Development Facilitation Team (DHO) – Review Comments

Project No: PR-2022-006935 Date: 12/06/2023 Agenda Item: 12 Zone Atlas Page: G-21

Application For: SD-2023-00191/SD-2023-00192/SD-2023-00193/SD-2023-00194/SD-2023-00210 – Vacation of Public Easements (3) and portion of one ROW/Preliminary Plat

SUBJECT: Vacation of Right of Way, Vacation of Easement, Preliminary Plat

ENGINEER'S SEAL 	<b>JUAN TABO BUSINESS PARK</b> ALBUQUERQUE, NM	DRAWN BY RG
	<b>SIDEWALK EXHIBIT</b>	DATE 10-23-23
	<b>TIERRA WEST, LLC</b> 5571 MIDWAY PARK PL NE ALBUQUERQUE, NEW MEXICO 87109 (505) 858-3100 www.tierrowestllc.com	DRAWING
JAY G. MILLER P.E. #14505		SHEET # JOB # 2022122

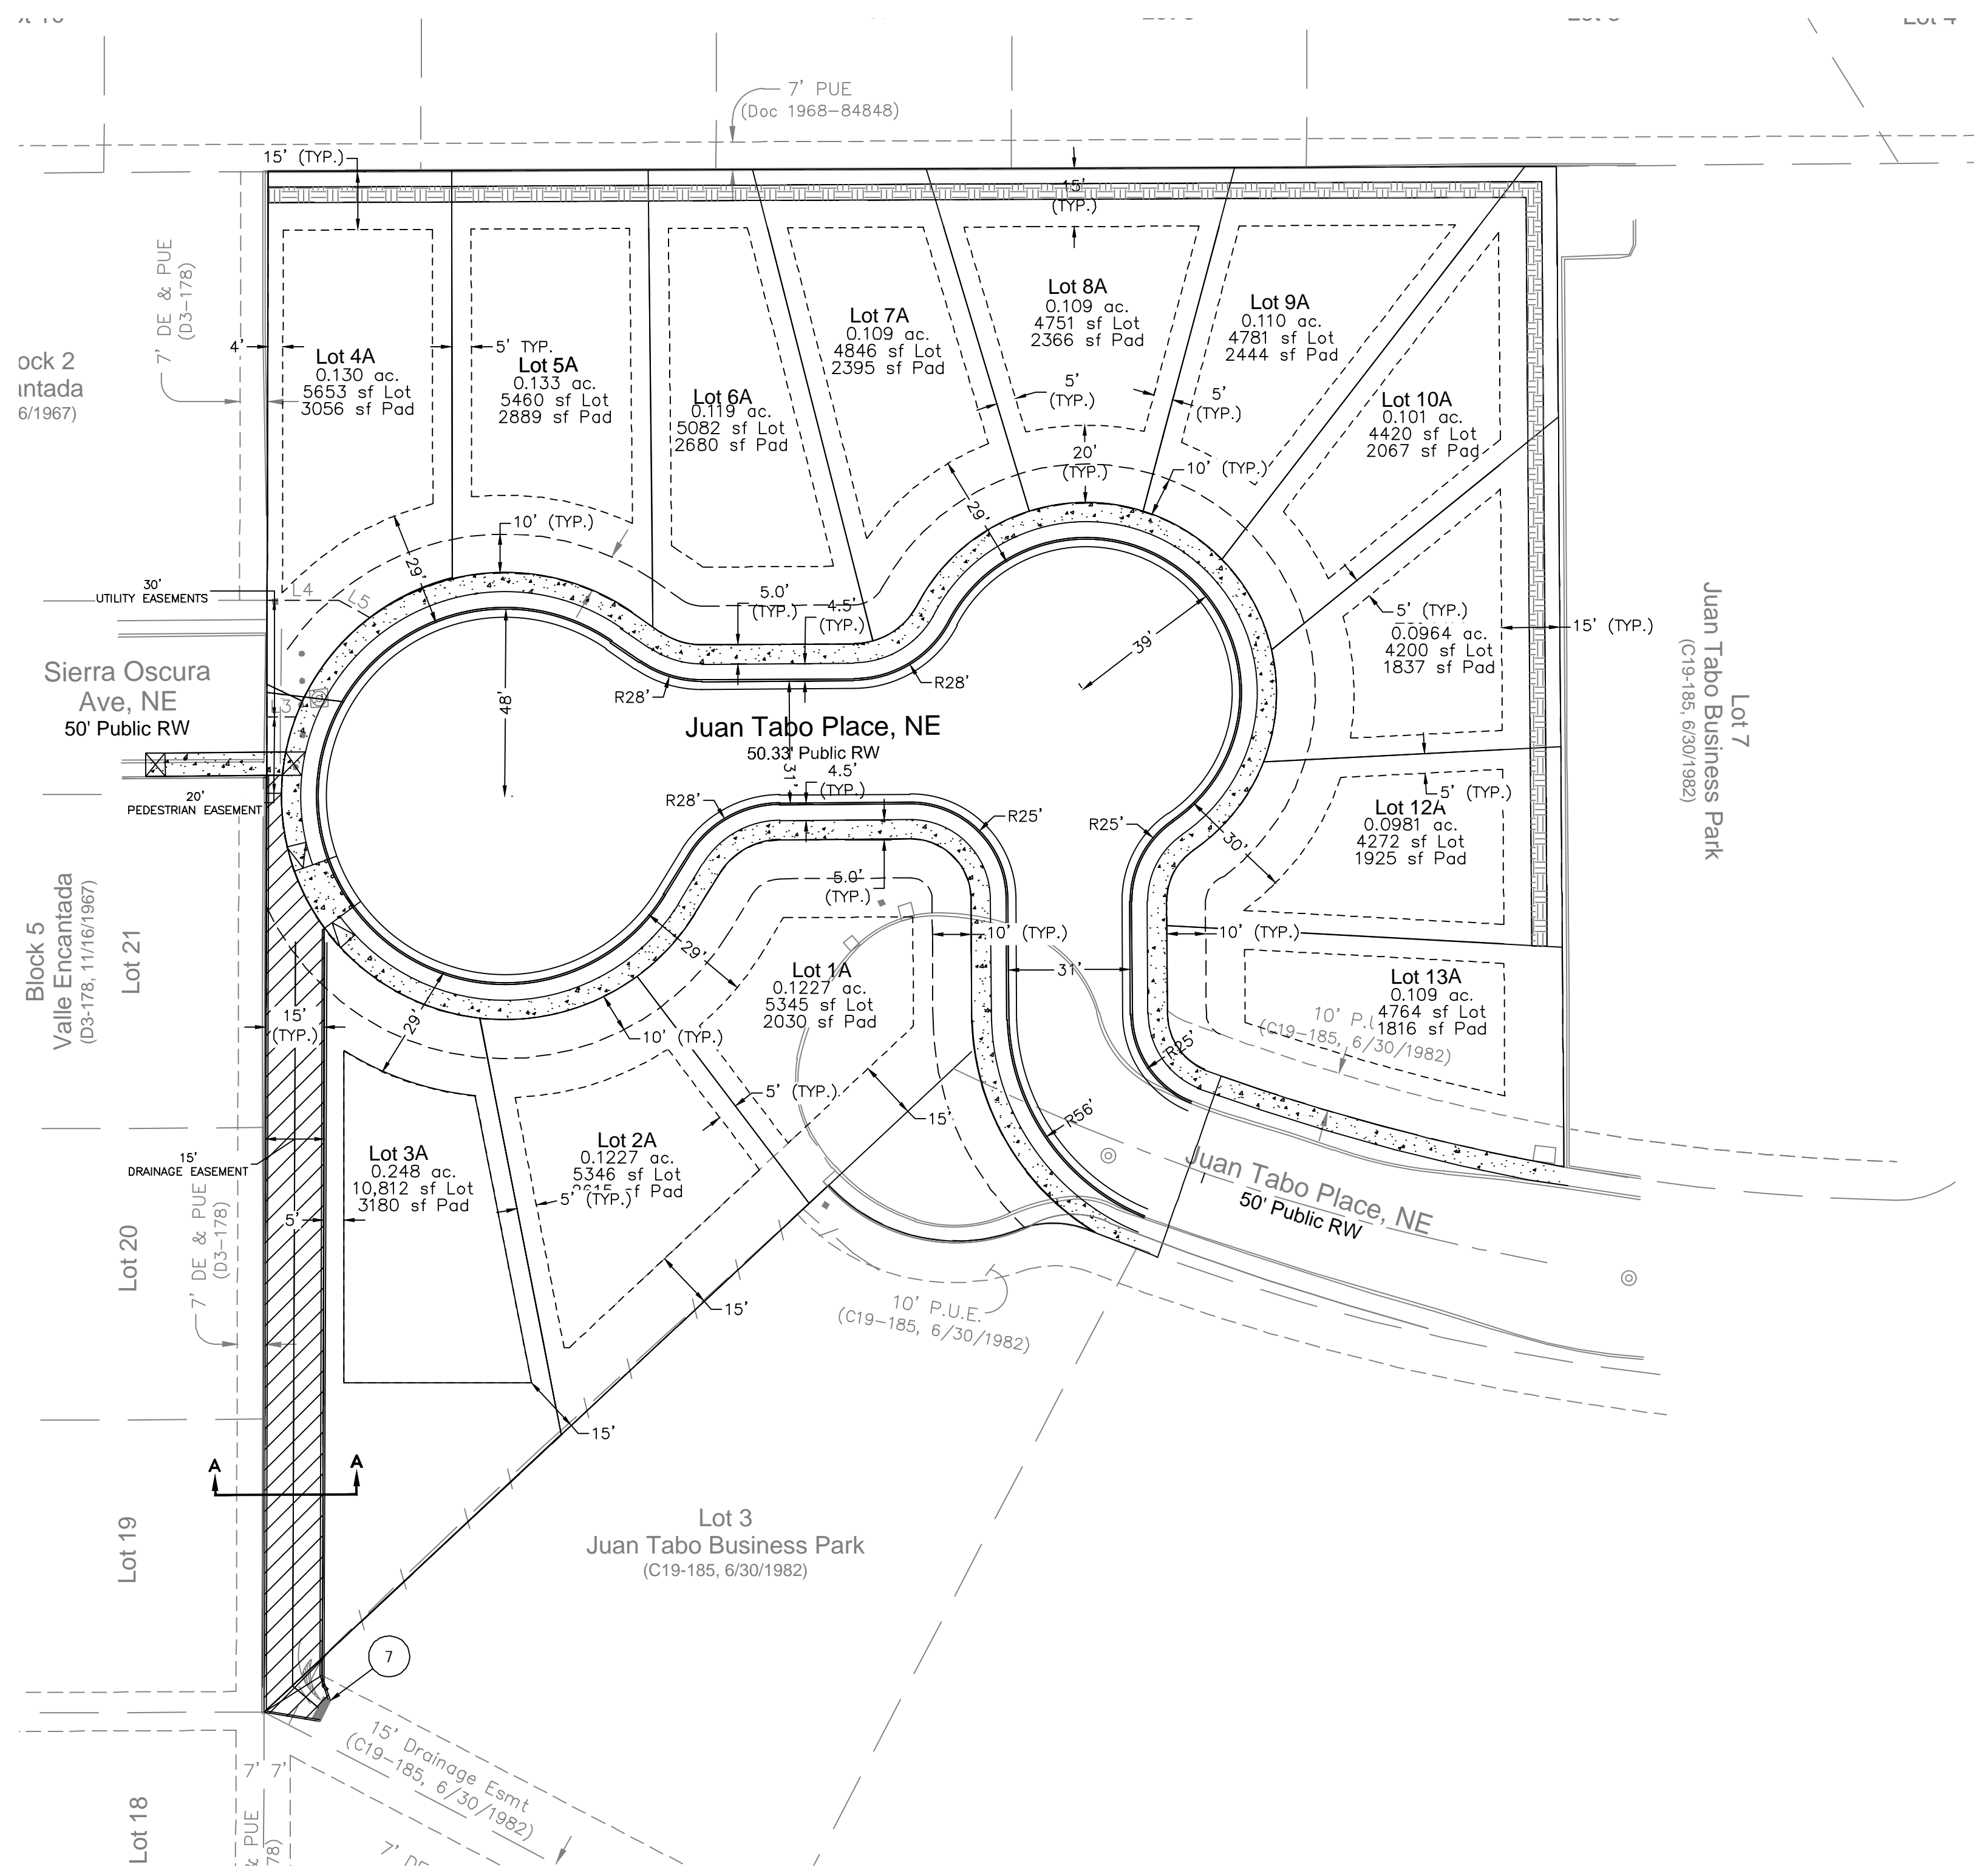
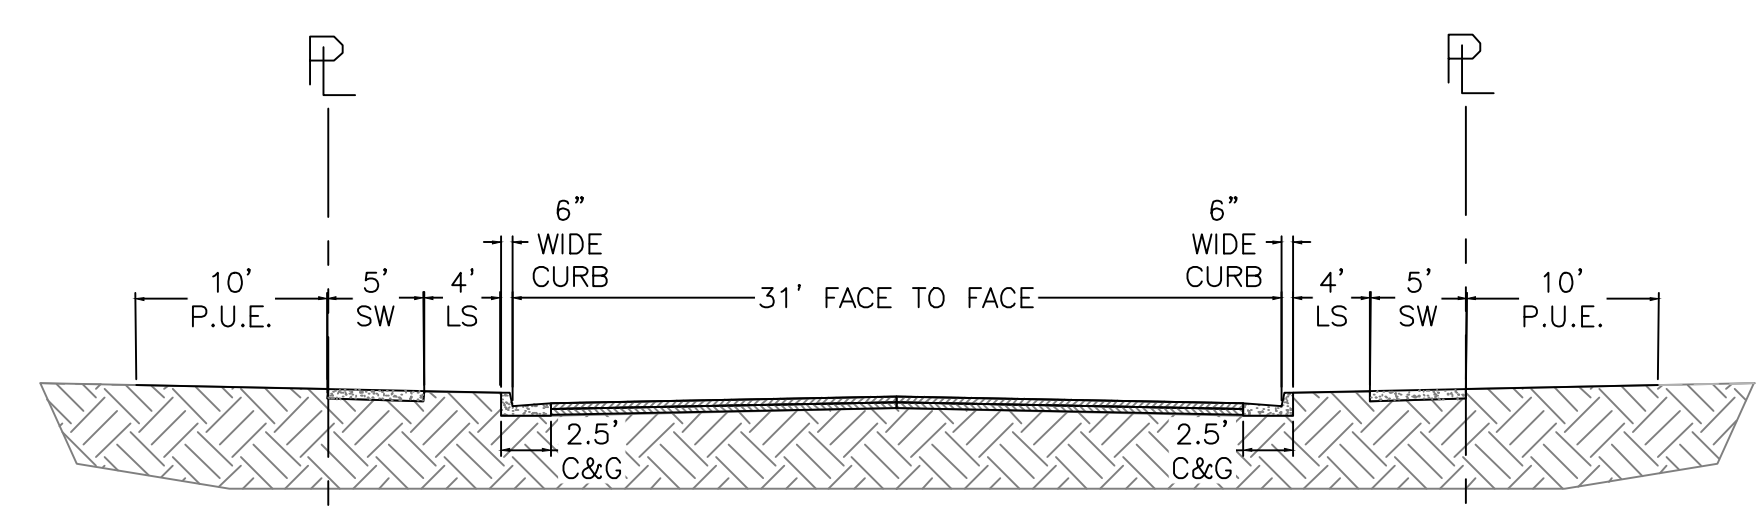
1. No objection to the vacations.
2. For both existing portions and proposed portions, Juan Tabo Pl. is considered a local street and requires 5' sidewalks and 4-6' landscape buffers. Show cross-sections to ensure it will be located within right-of-way, and dedicate any right-of-way as necessary. Your current drawings show sidewalk and buffer but there are no dimensions and you have not provided an infrastructure list. All infrastructure shall be placed onto an infrastructure list and be reviewed through the work order process.

Provide measurement for the existing ROW and distance from curb to property line along street frontages.

*Juan Tabo Pl. is considered a local street and requires 5' sidewalks and 4-6' landscape buffers.
